Job no 120029

10 November 2025

Secondary Innovation Precinct (SIP) and Campus Commons – Preliminary fire safety engineering review

Jensen Hughes has been commissioned by Pymble Ladies' College (the College) to prepare this fire safety engineering statement in accordance with the technical requirements of the Secretary's Environmental Assessment Requirements (SEARs) and in support of the preparation of an Environmental Impact Statement (EIS) and State Significant Development Application (SSD-79146716) to the Department of Planning, Housing and Infrastructure (DPHI). This statement has been prepared with reference to the architectural plans prepared by 3XN dated March 2025. Refer to Appendix A.

DRAWING
SECTION - NORTH / SOUTH 02 -
AUDITORIUM
DRAWING NUMBER
AR-SIP-DA-A07-1001
ISSUE
4

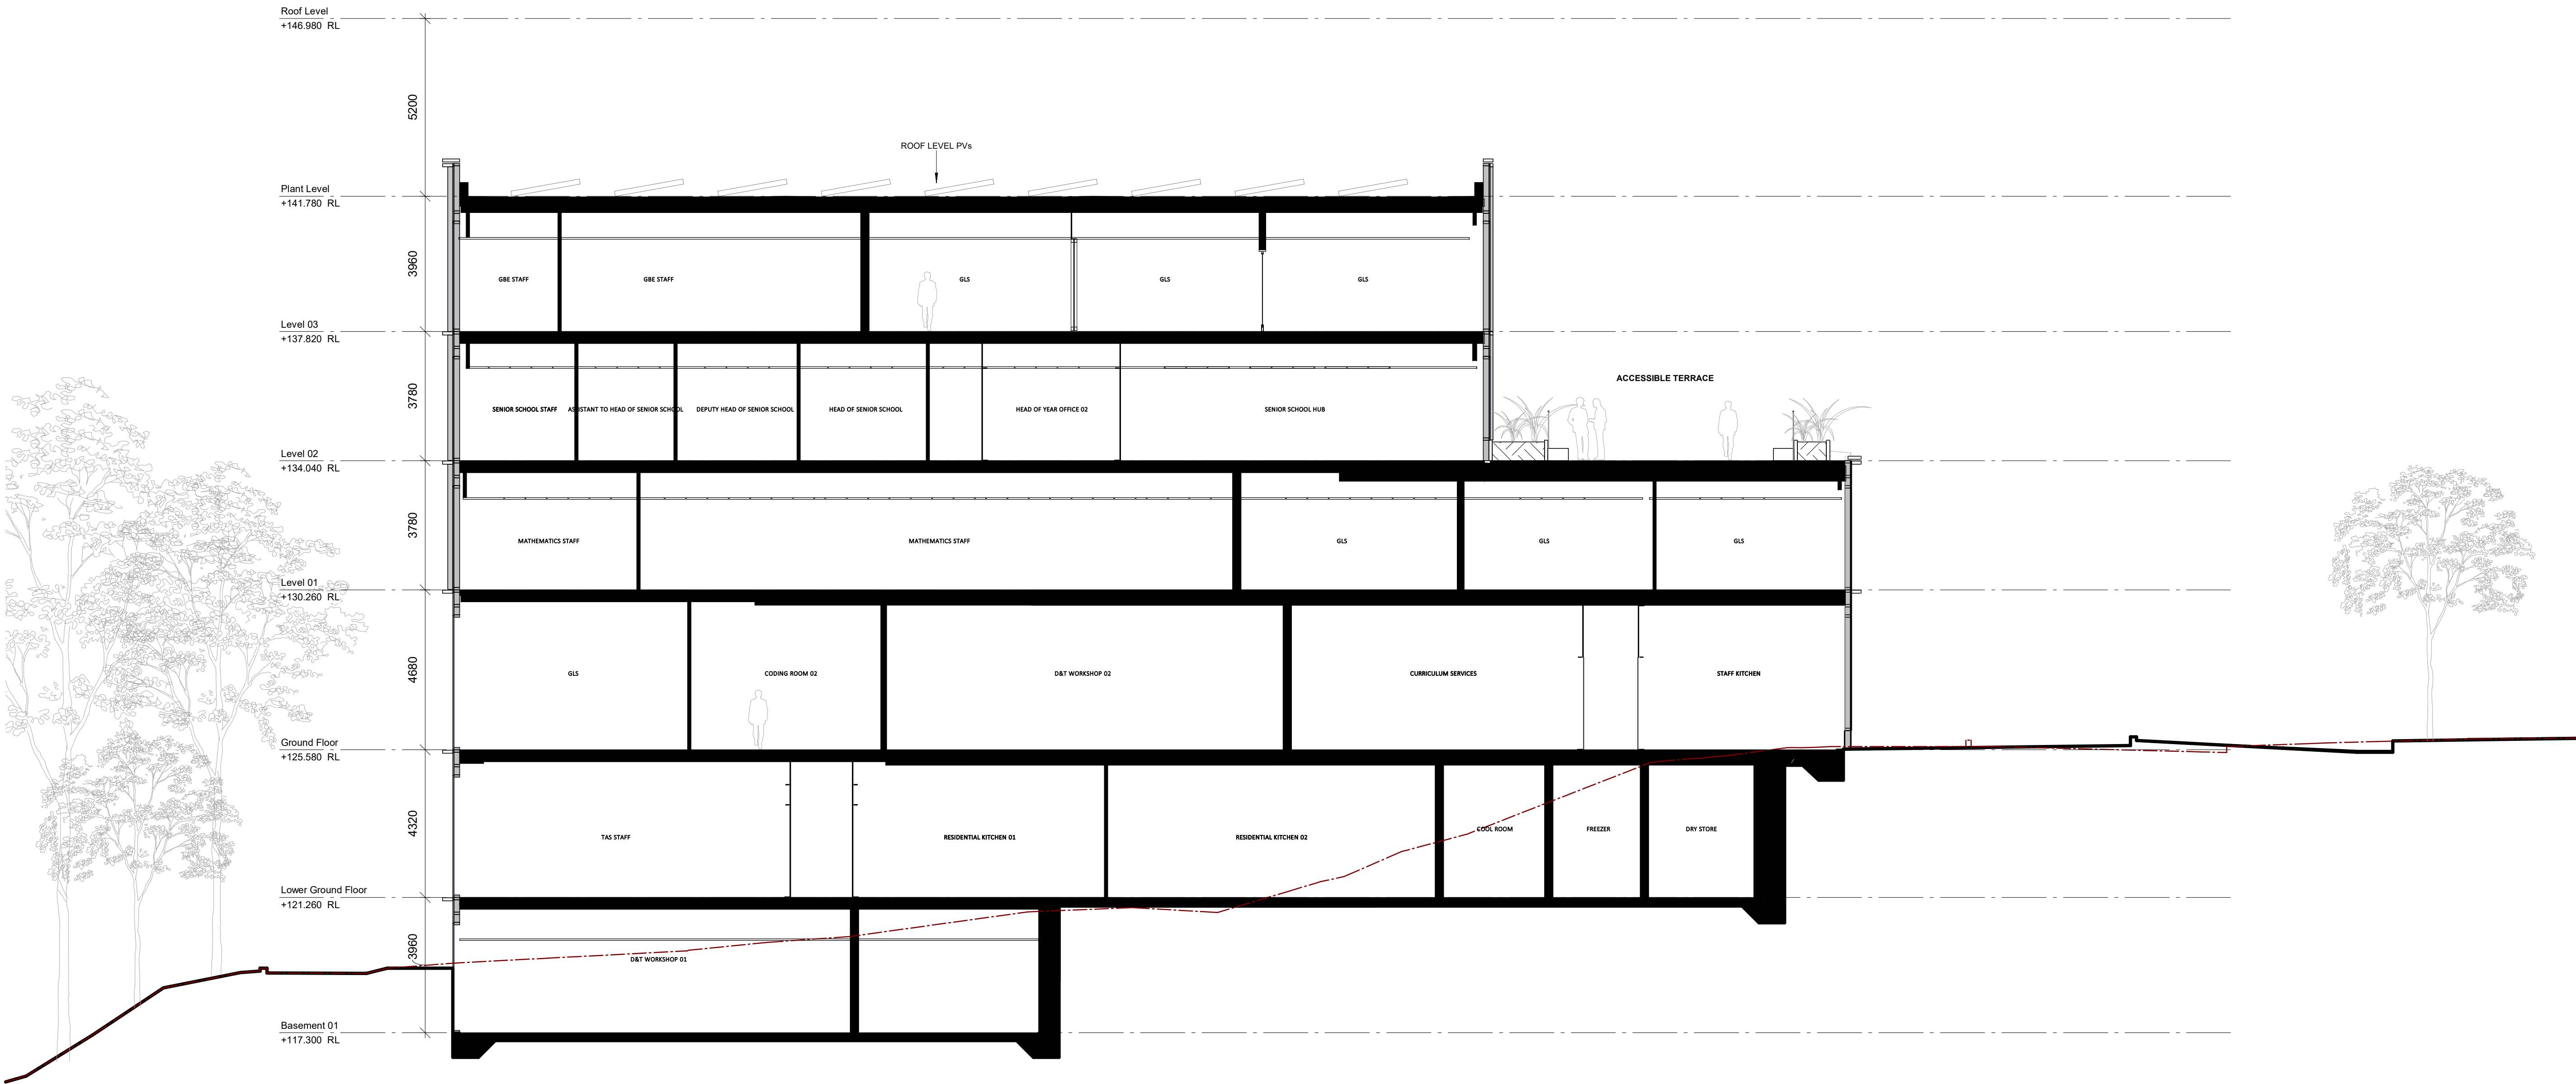
12.	The following fire services will not be provided below the retractable seating in the auditorium due to the nature of its use: - Sprinklers - Smoke detection - Fire hydrant coverage - Fire hose reel coverage	Clauses E1D2, E1D3, E1D4 and E2D9	E1P1, E1P3, E1P4 and E2P2	Qualitative assessment demonstrating that there is no credible risk of a fire starting underneath the retractable seating. The space underneath the retractable seating will be kept clear of combustible items, reinforced through signage and housekeeping procedures.
